Application No: FP/32/21/PL
Site Address: Land adjacent to 10 Second Avenue Felpham PO22 7LJ
Description of works: Two storey, 4 Bed detached dwelling with new access & parking. This site is in CIL Zone 4 & is CIL Liable as new dwelling.

Thank you for your internet representation made on 31st March 2021 which has been recorded as an objection with the comments as follows:

Site Plan (scale 1:500)

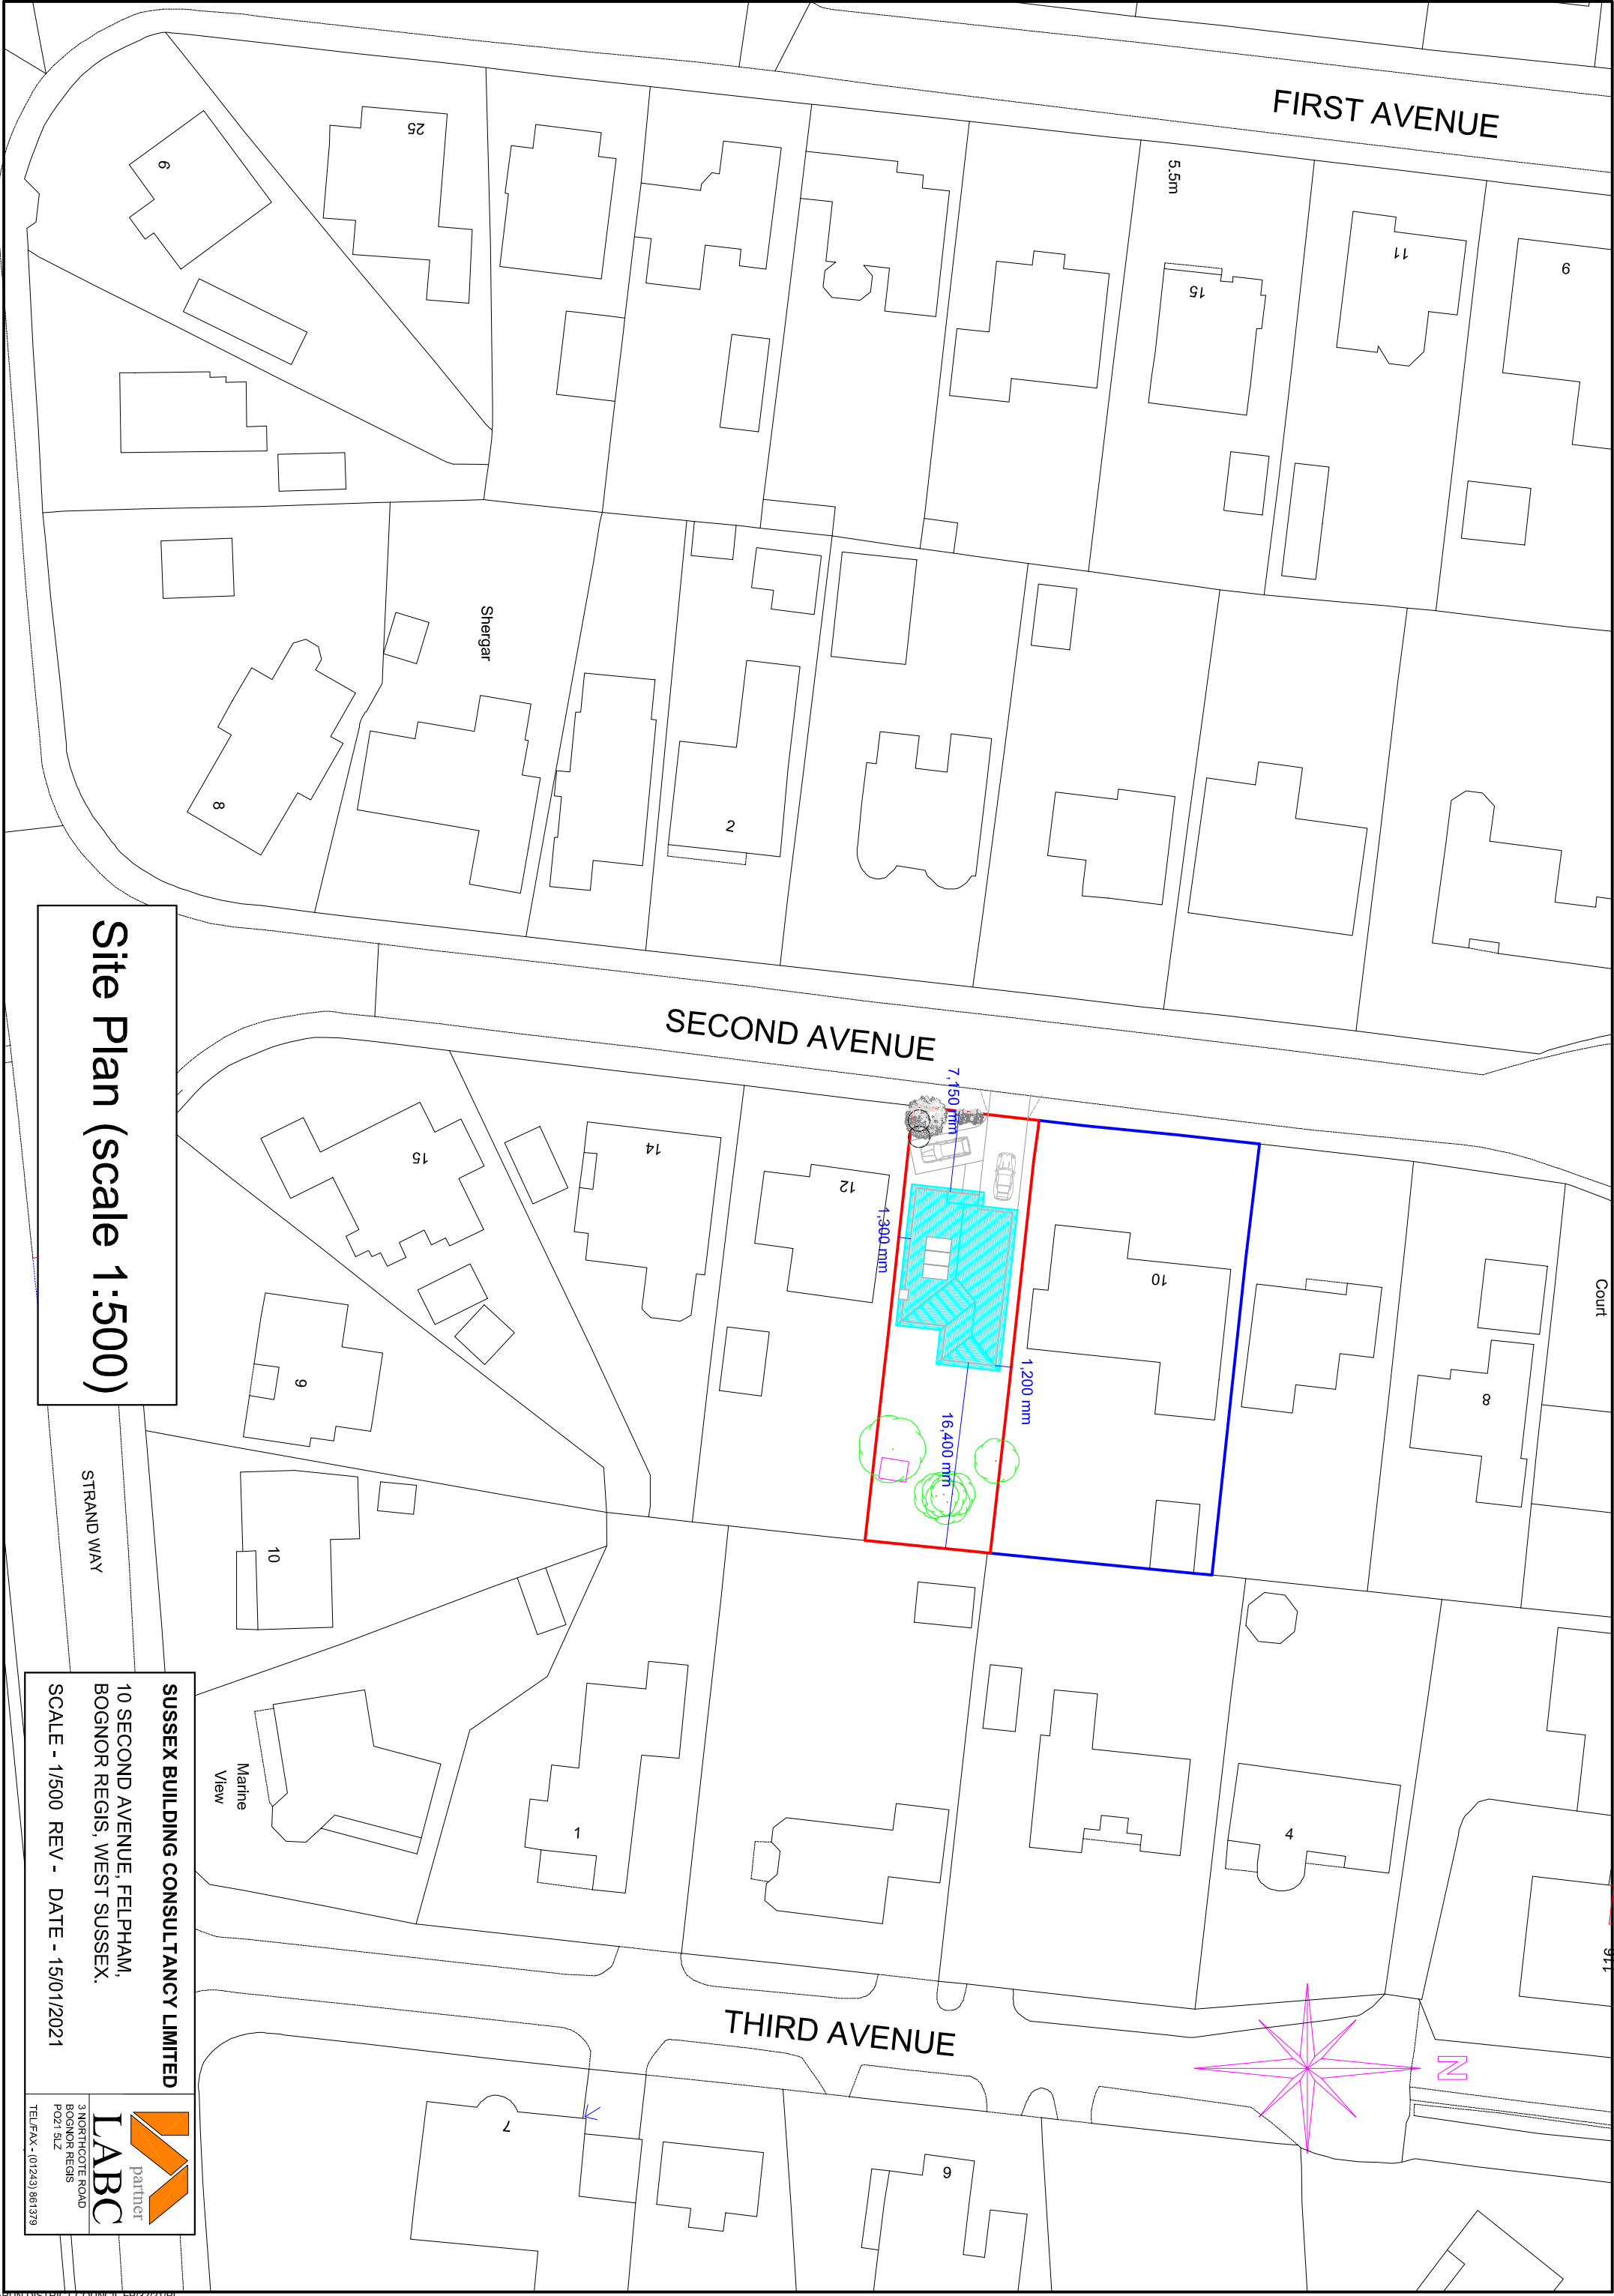
- We believe our right of light will be greatly effected to 4 No. windows which runs parallel to our house.
- We believe the rear extension to the proposed development will greatly effect our light.
- In regards to the point above, it appears the Site Plan shows No. 10 having a similar projection to the rear, however this is in fact a conservatory, we feel the proposed extension will have a large visual impact also, which is something we considered when doing our own development. On this point we believe that a single storey extension must be considered.
- The overall size of the build is a concern, a similar plot was approved in recent years, which looks overpowering and squeezed in. It also received many rejections and continues to cause much debate on this estate.

FRONT (WEST) ELEVATION

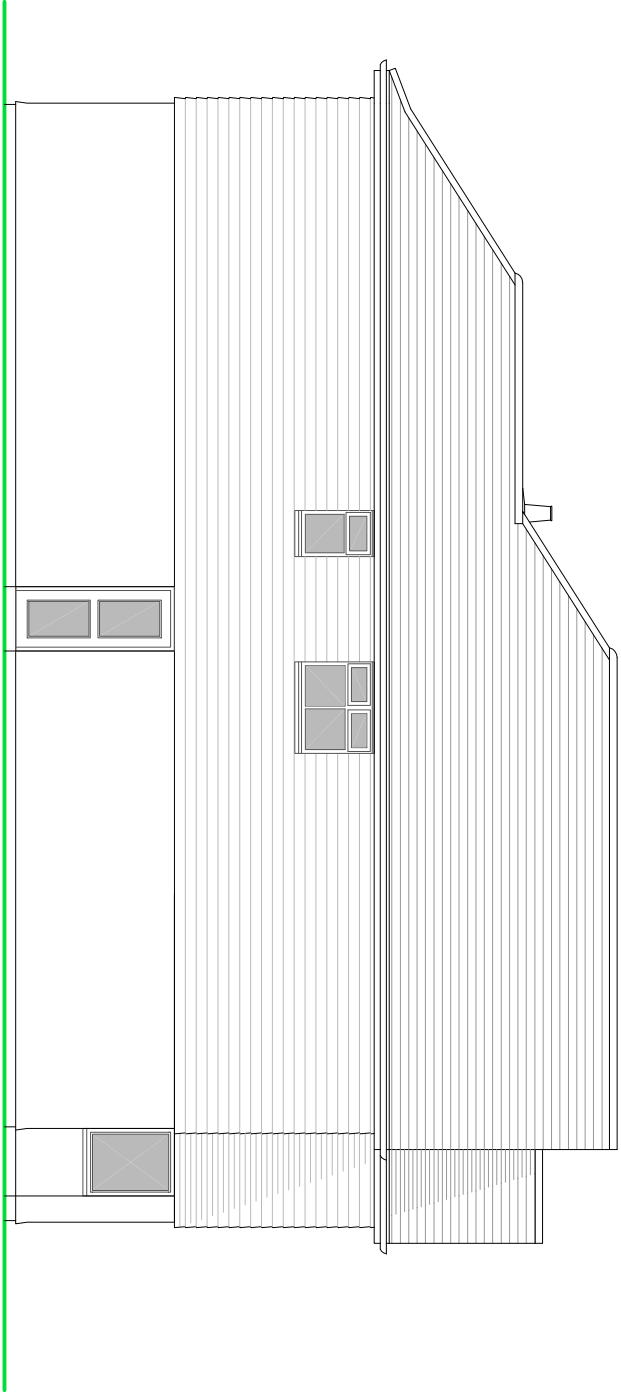
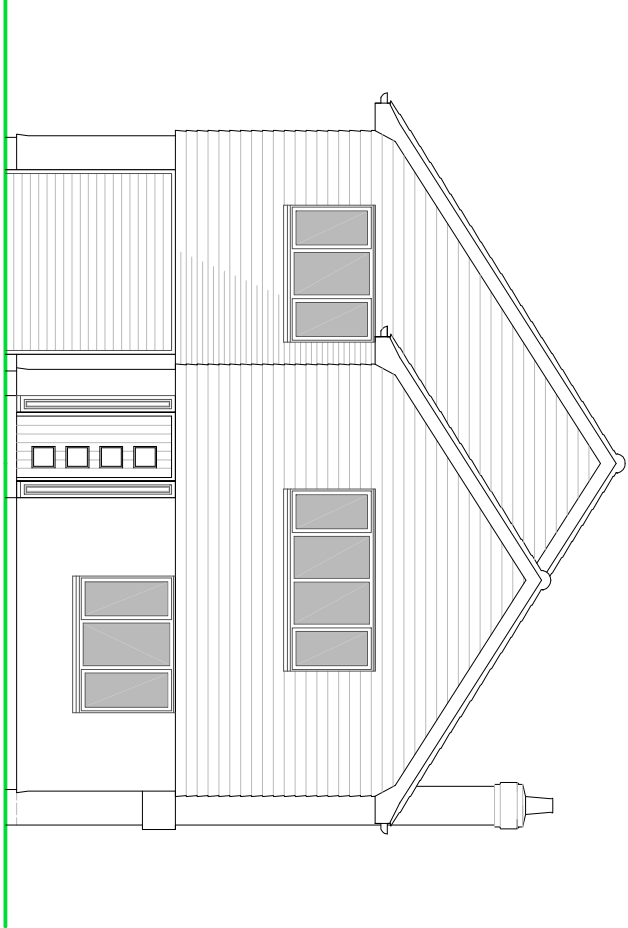
- The projection to the front of the house is switched to side of No. 10, this might help slightly with our light.
- By introducing hipped ends instead of gable ends this will assist with light and soften the elevations.

SIDE (SOUTH) ELEVATION

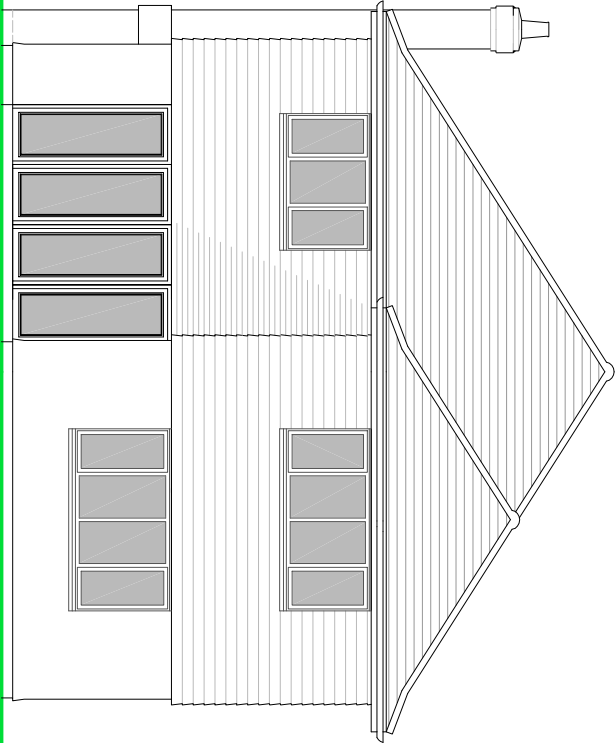
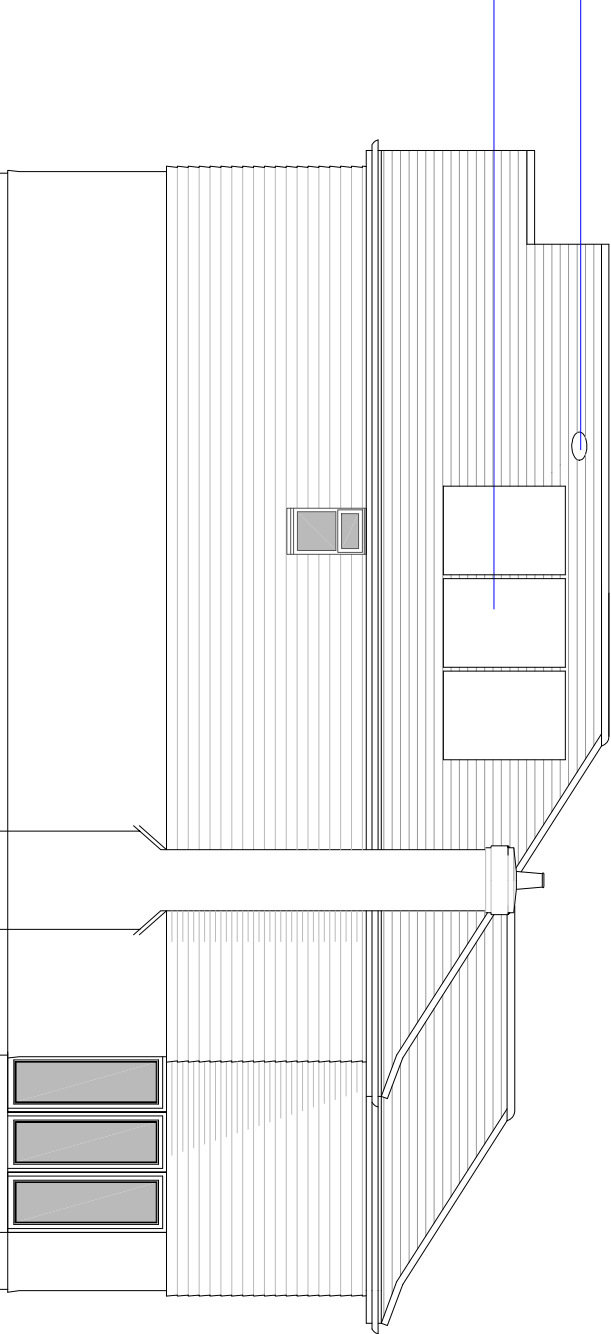
- The proposed projection to the rear is single storey only.
- We assume the windows to proposed South Elevations will be opaque.
- We have concern about the chimney proximity and it being lower in height than our own roof pitch, could there be a problem with smoke / vacuum etc. Could this also be switched to the other elevation?
